Consultation Response from KC, Conservation and Design
2020/94197 78, Wellhouse Green, Golcar, Huddersfield, HD7 4ET
Listed Building Consent for erection of two storey extension to side (within a Conservation Area)
Date Responded: 22/02/21 Responding Officer: Craig McHugh Responding Ref: CV2/267
REVISED
Significance of the heritage assets affected

Proposed side elevation (1:100)

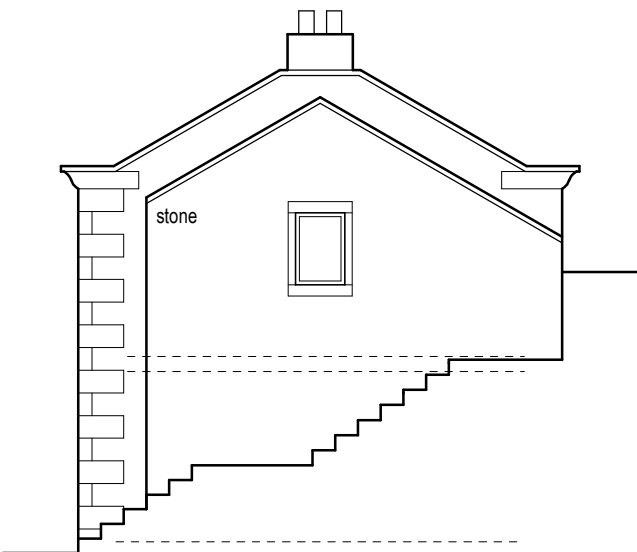
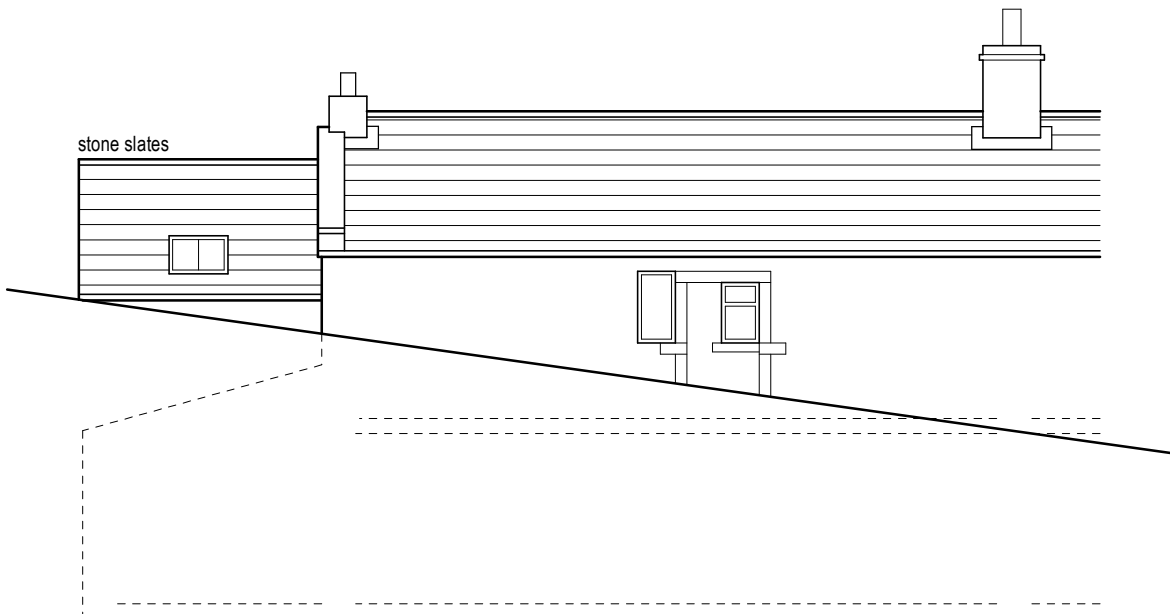
The proposed development would result in the loss of the lean-to extension, the first-floor windows and the blocked attic windows. The age of the lean-to extension is unknown. The window openings are original. The proposals would neither preserve nor enhance the listed building, they would cause a moderate level of harm, that harm would still be less than substantial harm.

Conservation and Design have concerns about the proposed development on heritage grounds, with particular regards to Section 16(2) of the Planning (Listed Buildings and Conservation Areas) Act 1990, Policy LP35 of the Local Plan and paragraphs 193 and 196 of the NPPF. Subject to a better understanding of the significance of the lean-to extension, a single-storey extension on the footprint proposed could be acceptable in principle. As currently submitted, the application should be refused or withdrawn by the applicant.

Proposed first floor layout (1:50)

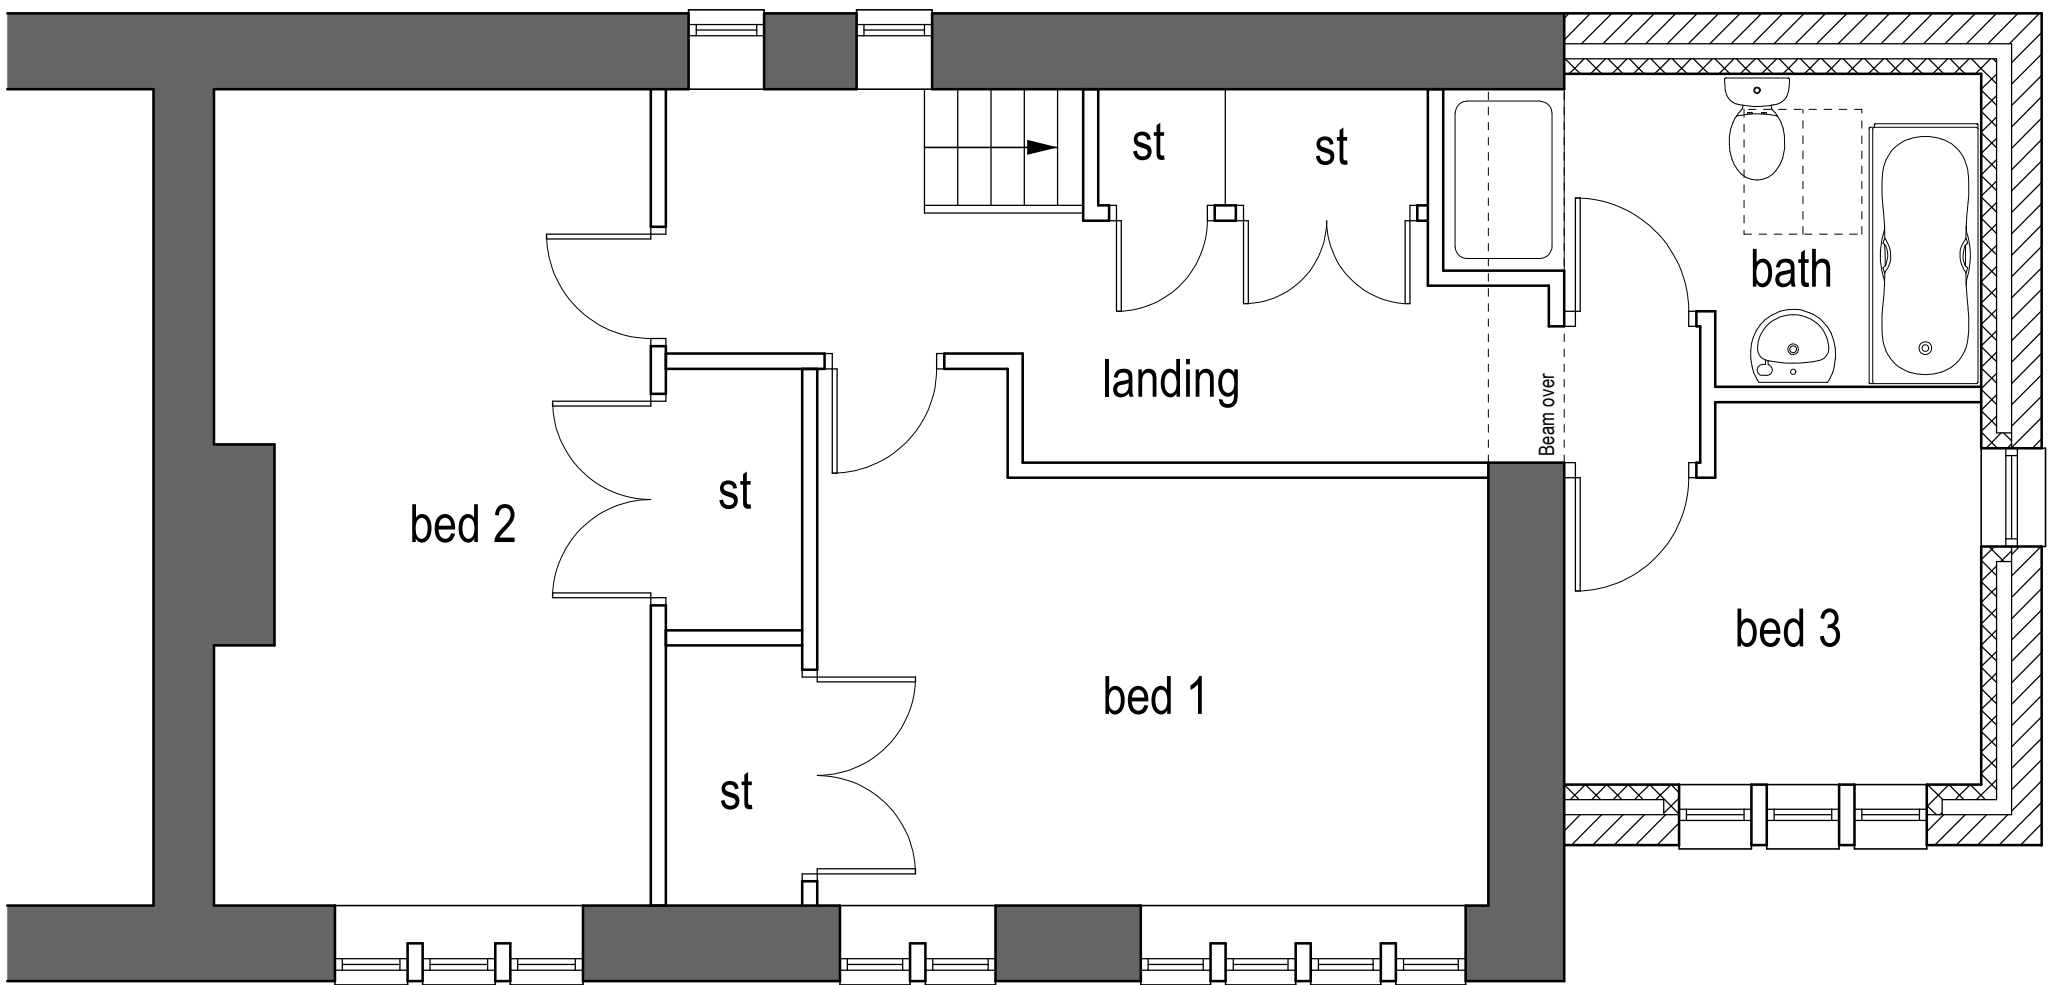
The proposed alterations would result in a large opening being formed at first floor between the existing house and the extension. This is in the vicinity of the chimney breast below (dining kitchen). There is no chimney breast shown at first floor in bedroom 1. However, photographs from around the time of listing show that the building previously had a chimney stack (now truncated without listed building consent) likely sufficient to serve two fireplaces.
